# **Submission to the Moss Vale Plastics Recycling Facility Environmental Impact Statement**

## **SSD-9409987**

Figure 3.1 Overview of existing wastewater system with the proposed gravity and facility

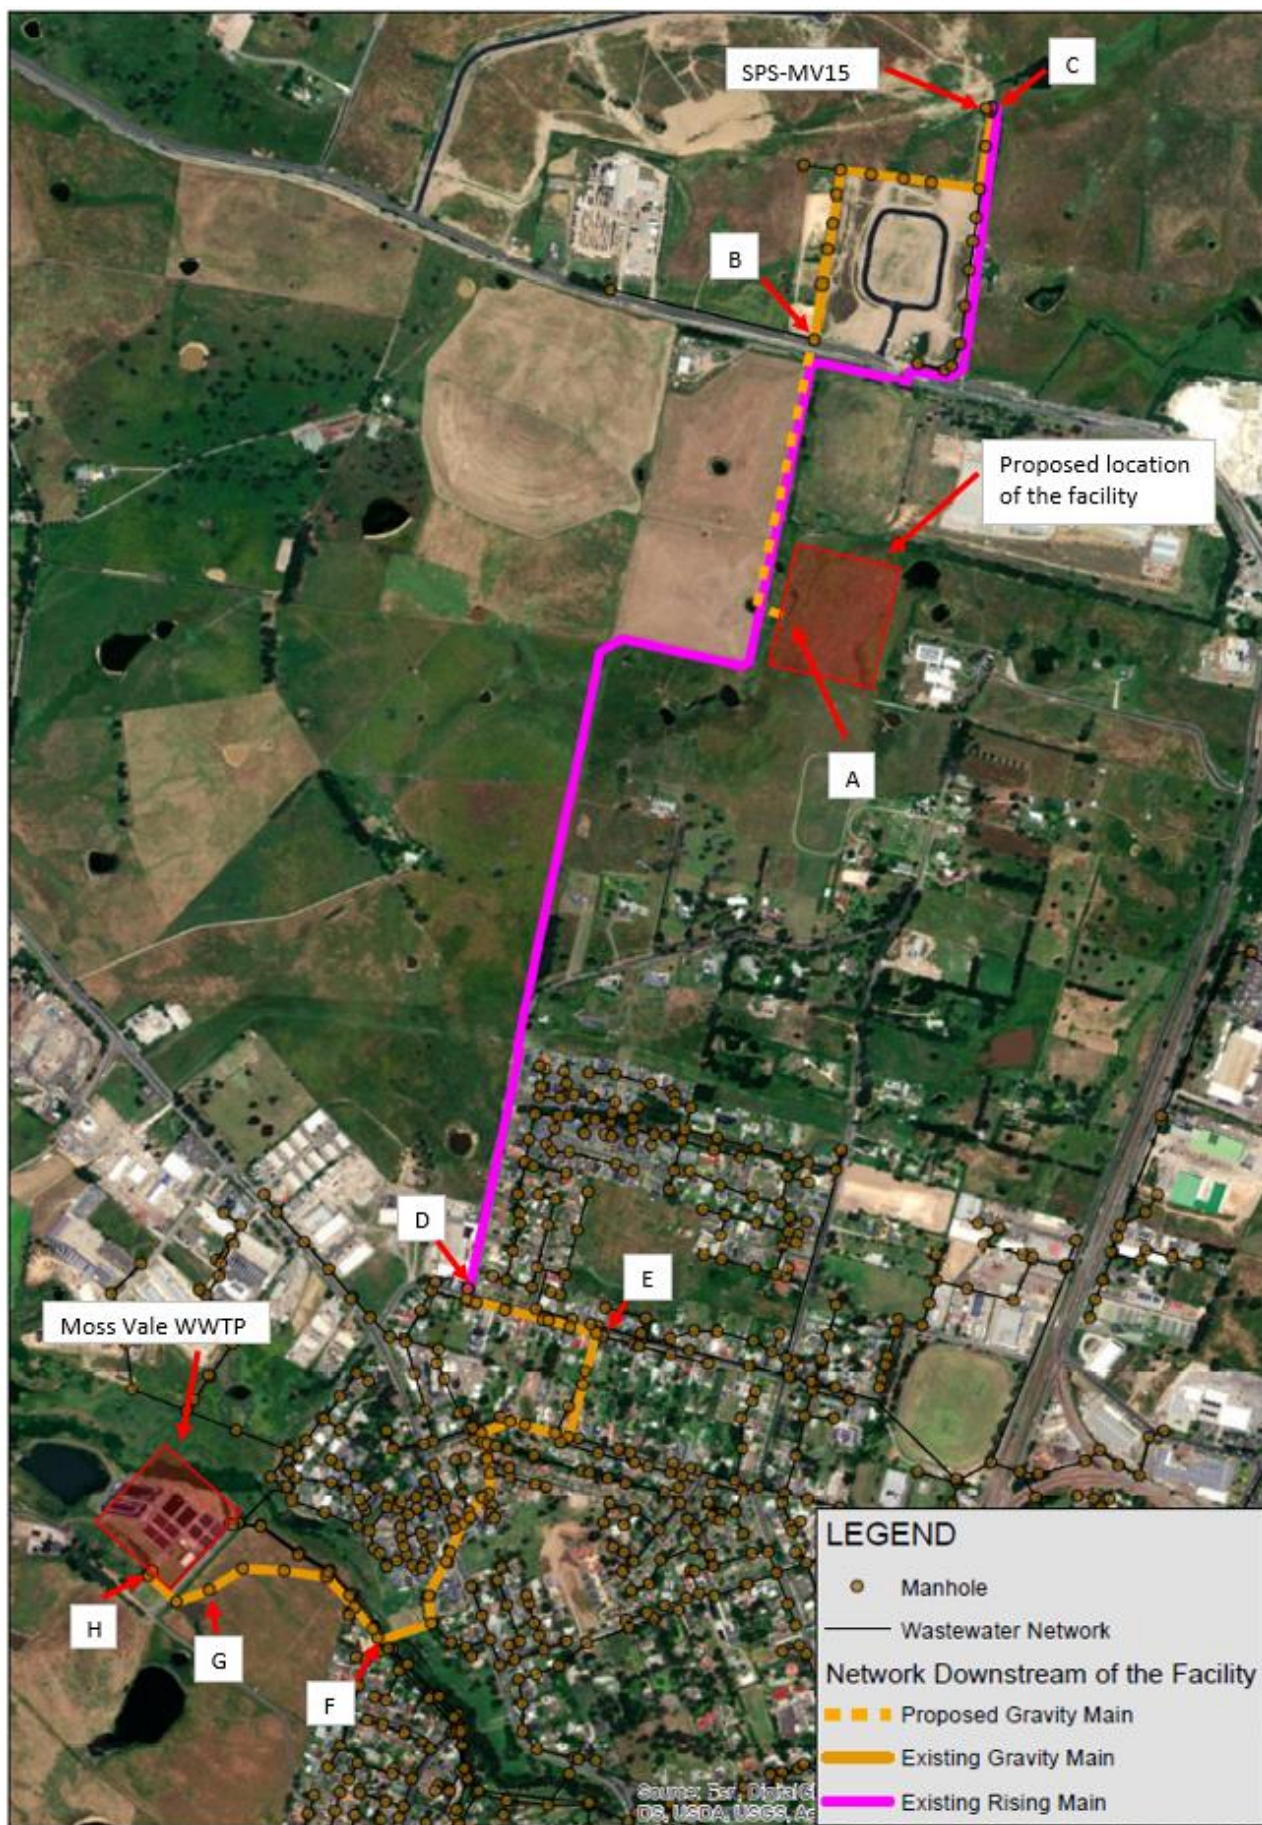
The subject site is serviced by the Moss Vale Waste Water Treatment Plant. As the EIS mentions, this facility is currently operating at capacity. Council has committed to an upgrade of the facility, but it will be several years before it is completed. Although the impact from the proposal is relatively small on a percentage basis of overall capacity, the Department should be advised that discharges from the proposed development will contribute to the Council's facility operating at, and over, capacity for several years.

24. Details on the quality of the wastewater is not provided in the EIS, therefore it is not possible to confirm if this can meet Council's trade waste requirements. There may be potential for microplastics and nanoplastics to be present in the liquid waste stream. No consideration has been given on the implications of this type of waste at Council's waste water treatment plant, and its ability to treat it. This requires further investigation, as additional onsite treatment processes may be needed prior to discharge.

Figure 4.2 Overview of water network

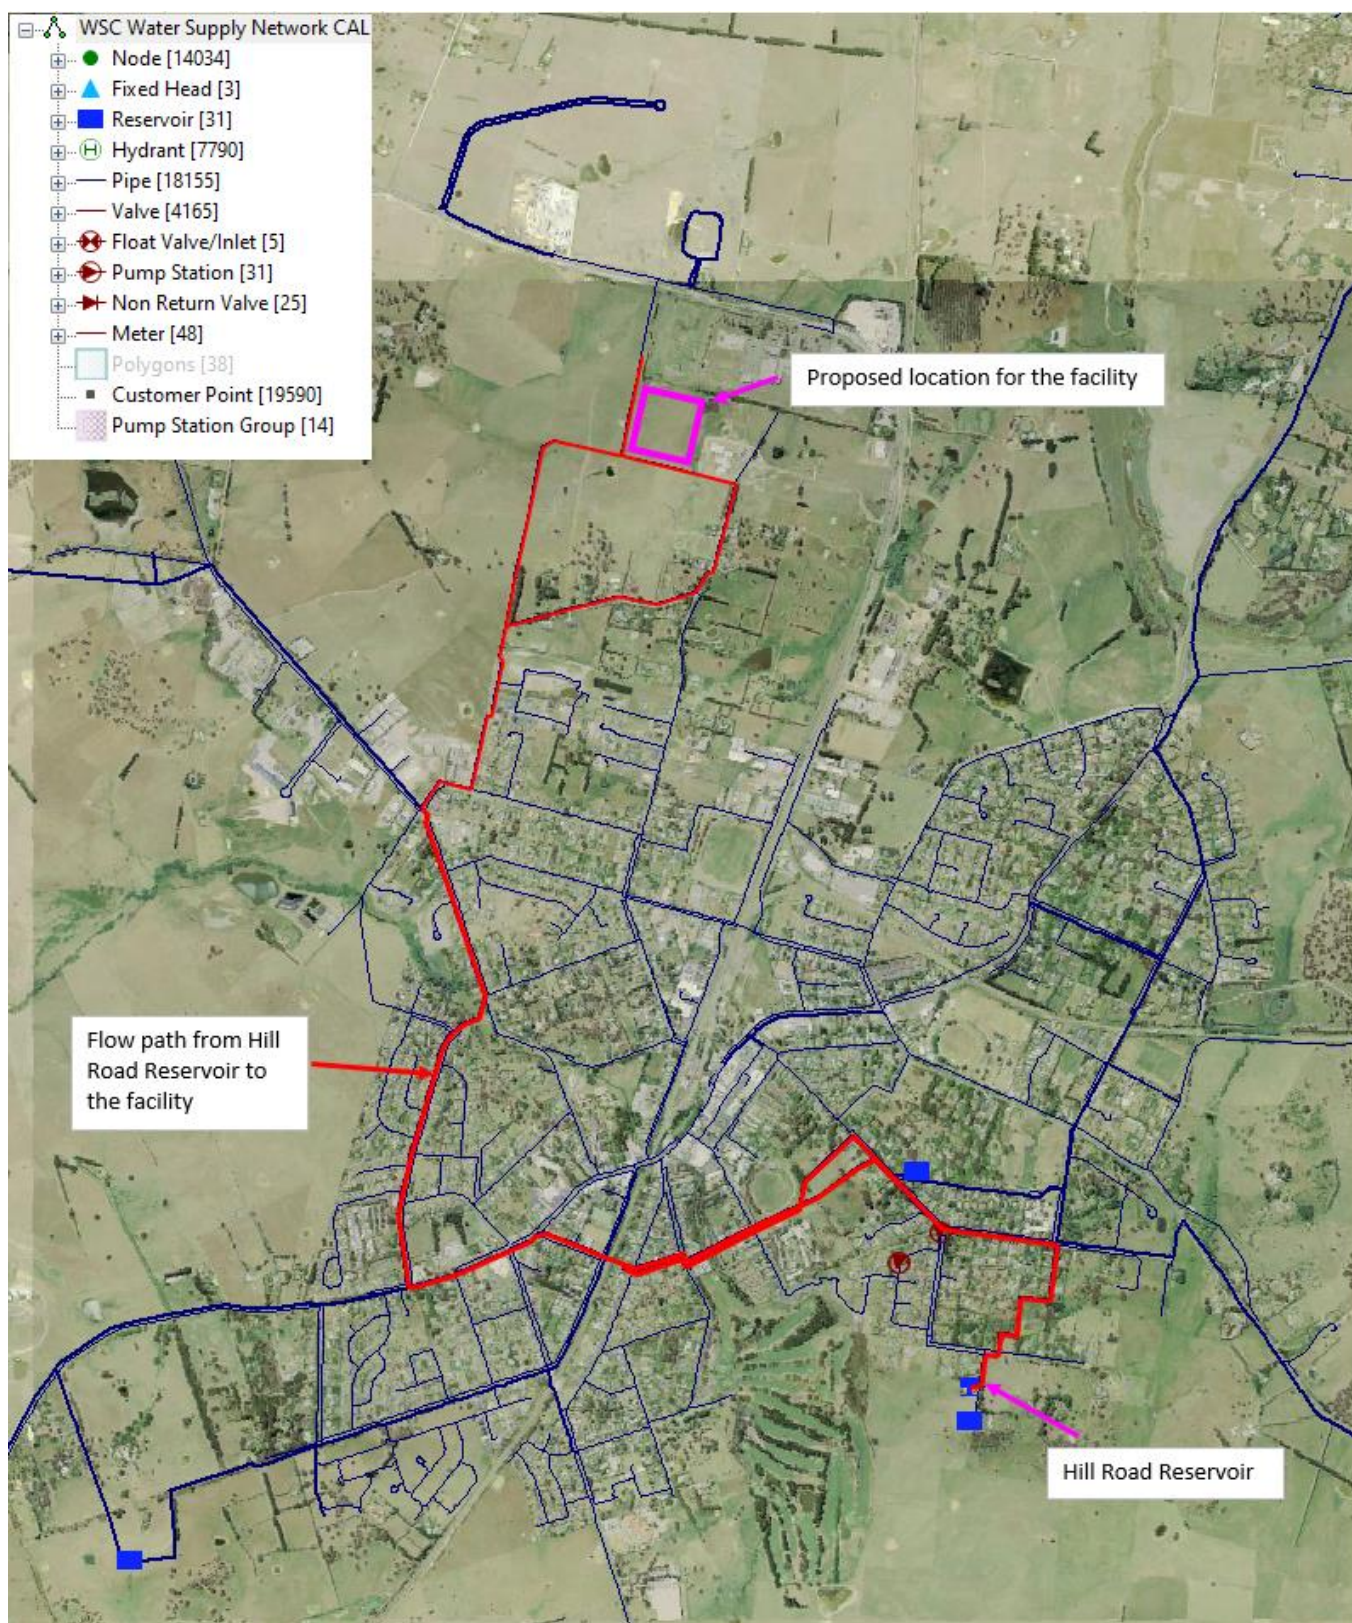
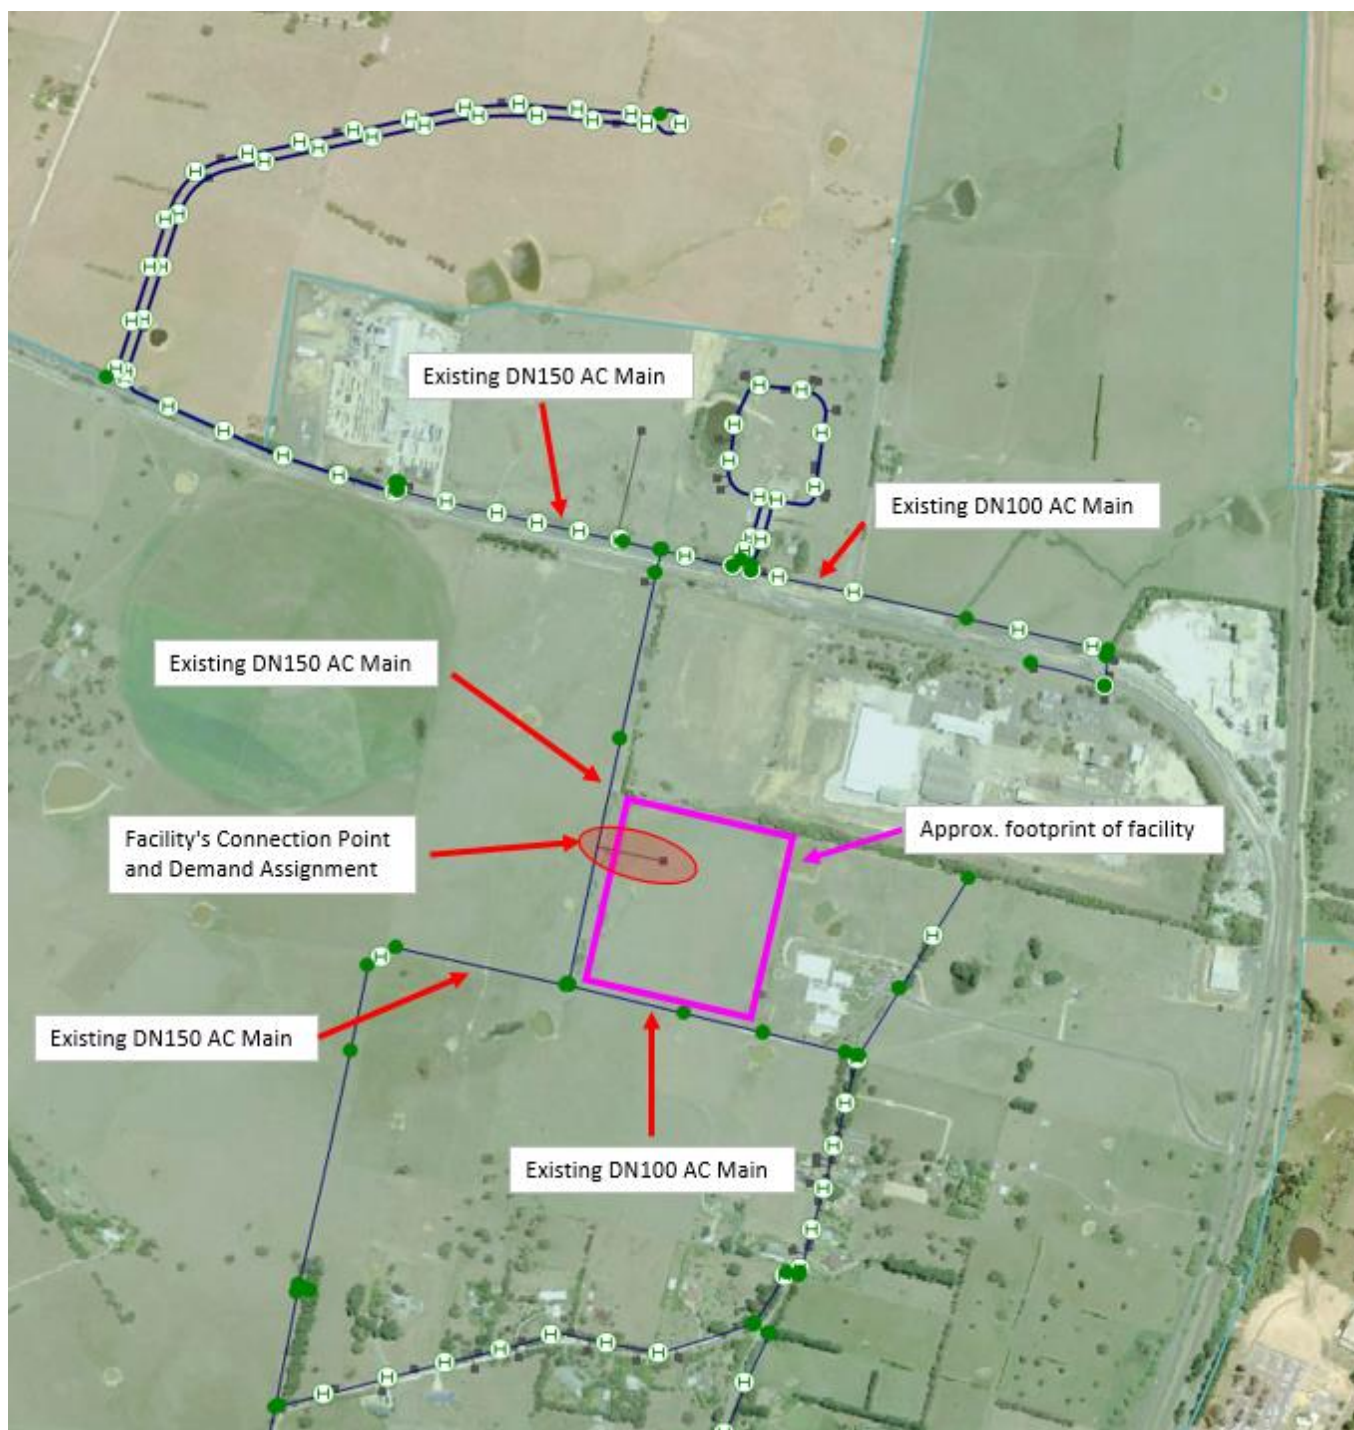
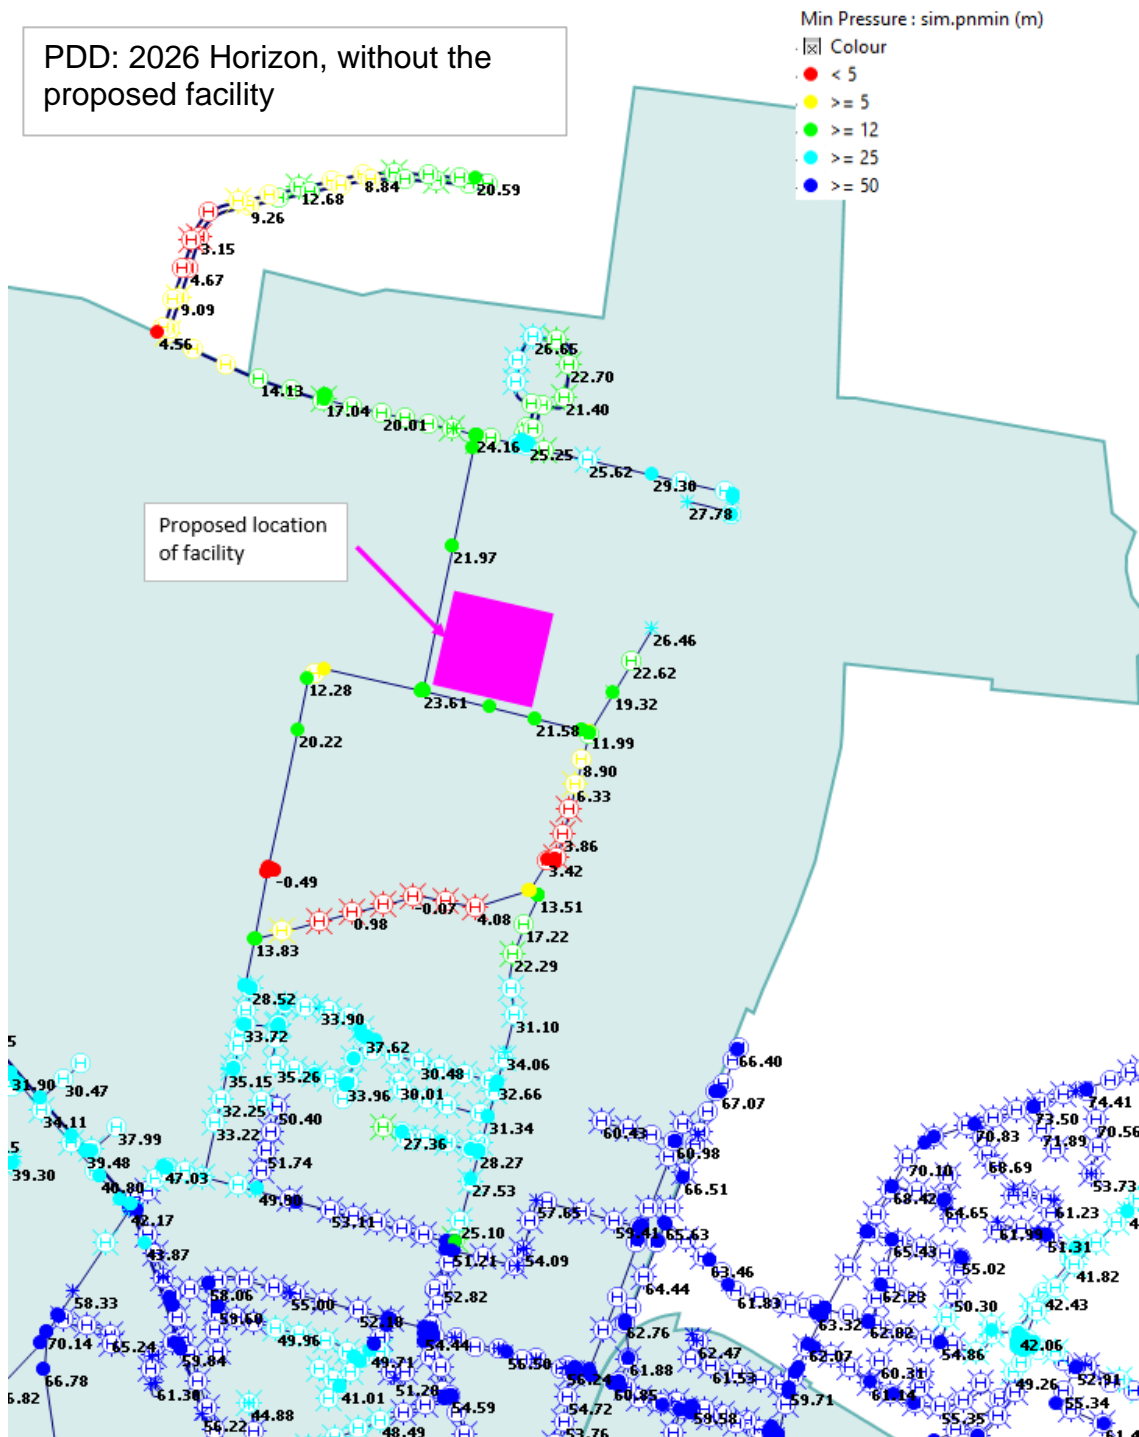
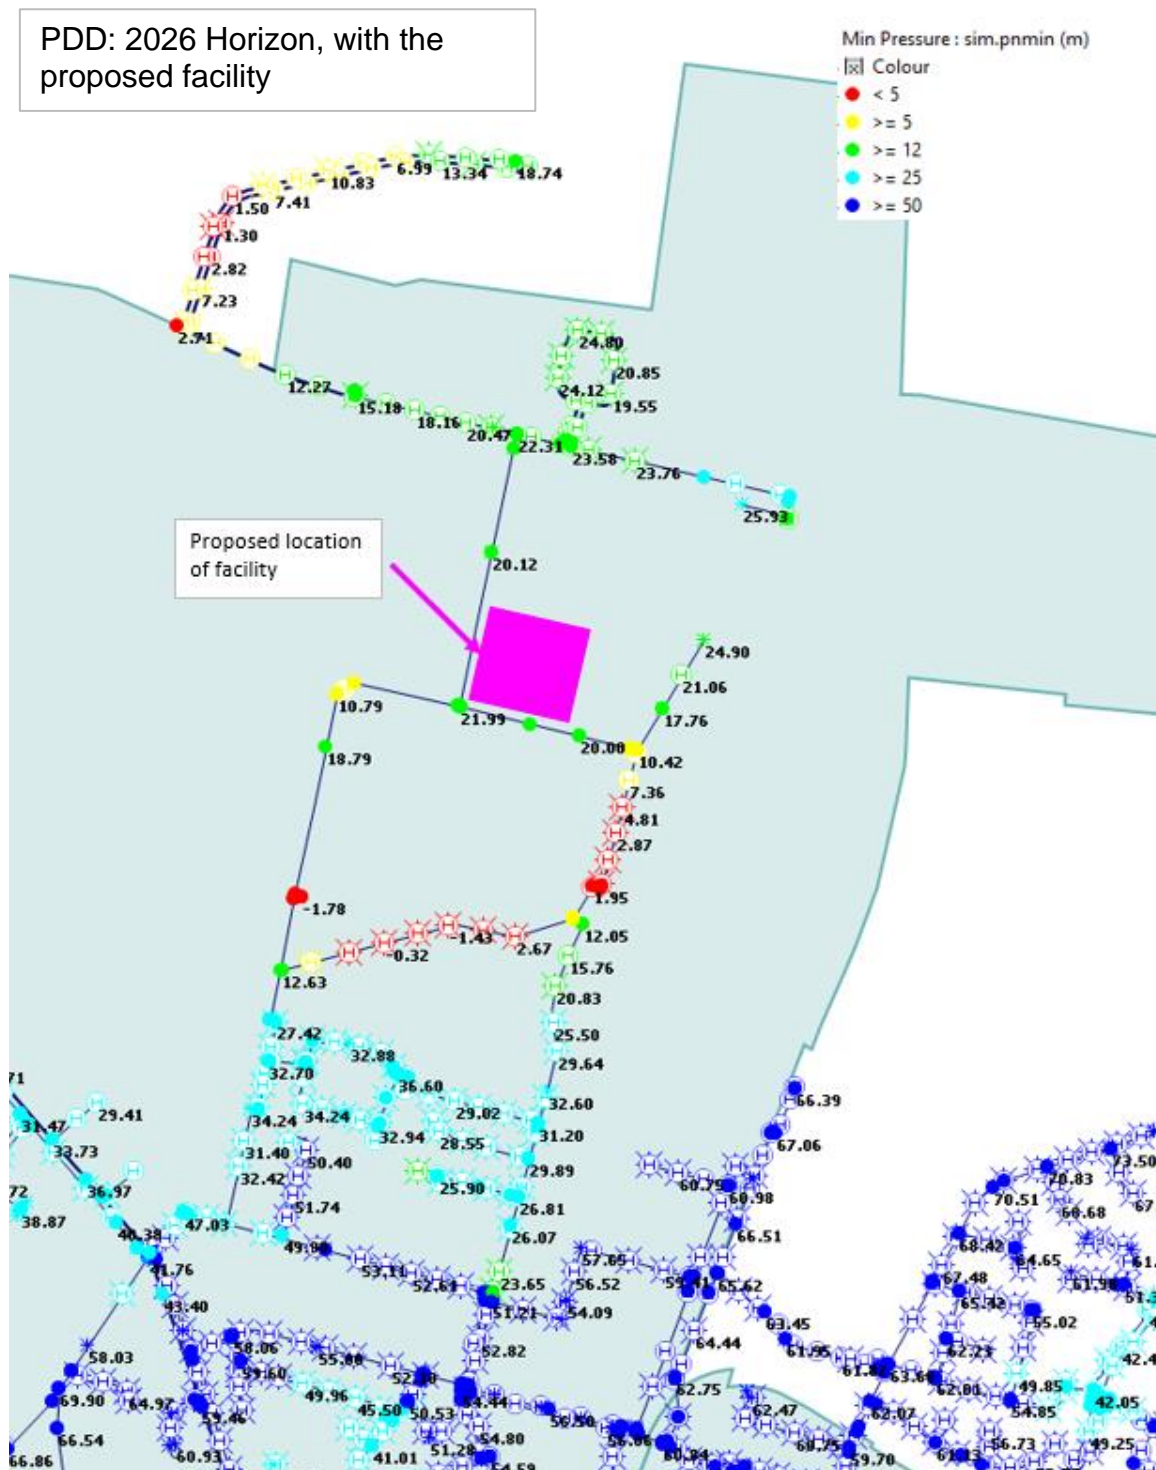
20. The proposed development will be a large consumer of water with a daily demand of 43.5 kL. This equates to about 16,900 kL/annum.
21. In the short term, it is shown there is capacity in the water networks to support the facility. However, there are known capacity issues in the Moss Vale water supply network in the near future. This will occur when plan development and infill demands come on line from 2026. Modelling in the EIS shows the water network cannot meet the demand in 2026.

23. Council is concern about approving an additional major water user to the water network, until there is more certainty about completion timeframes of these large scale essential water supply projects.
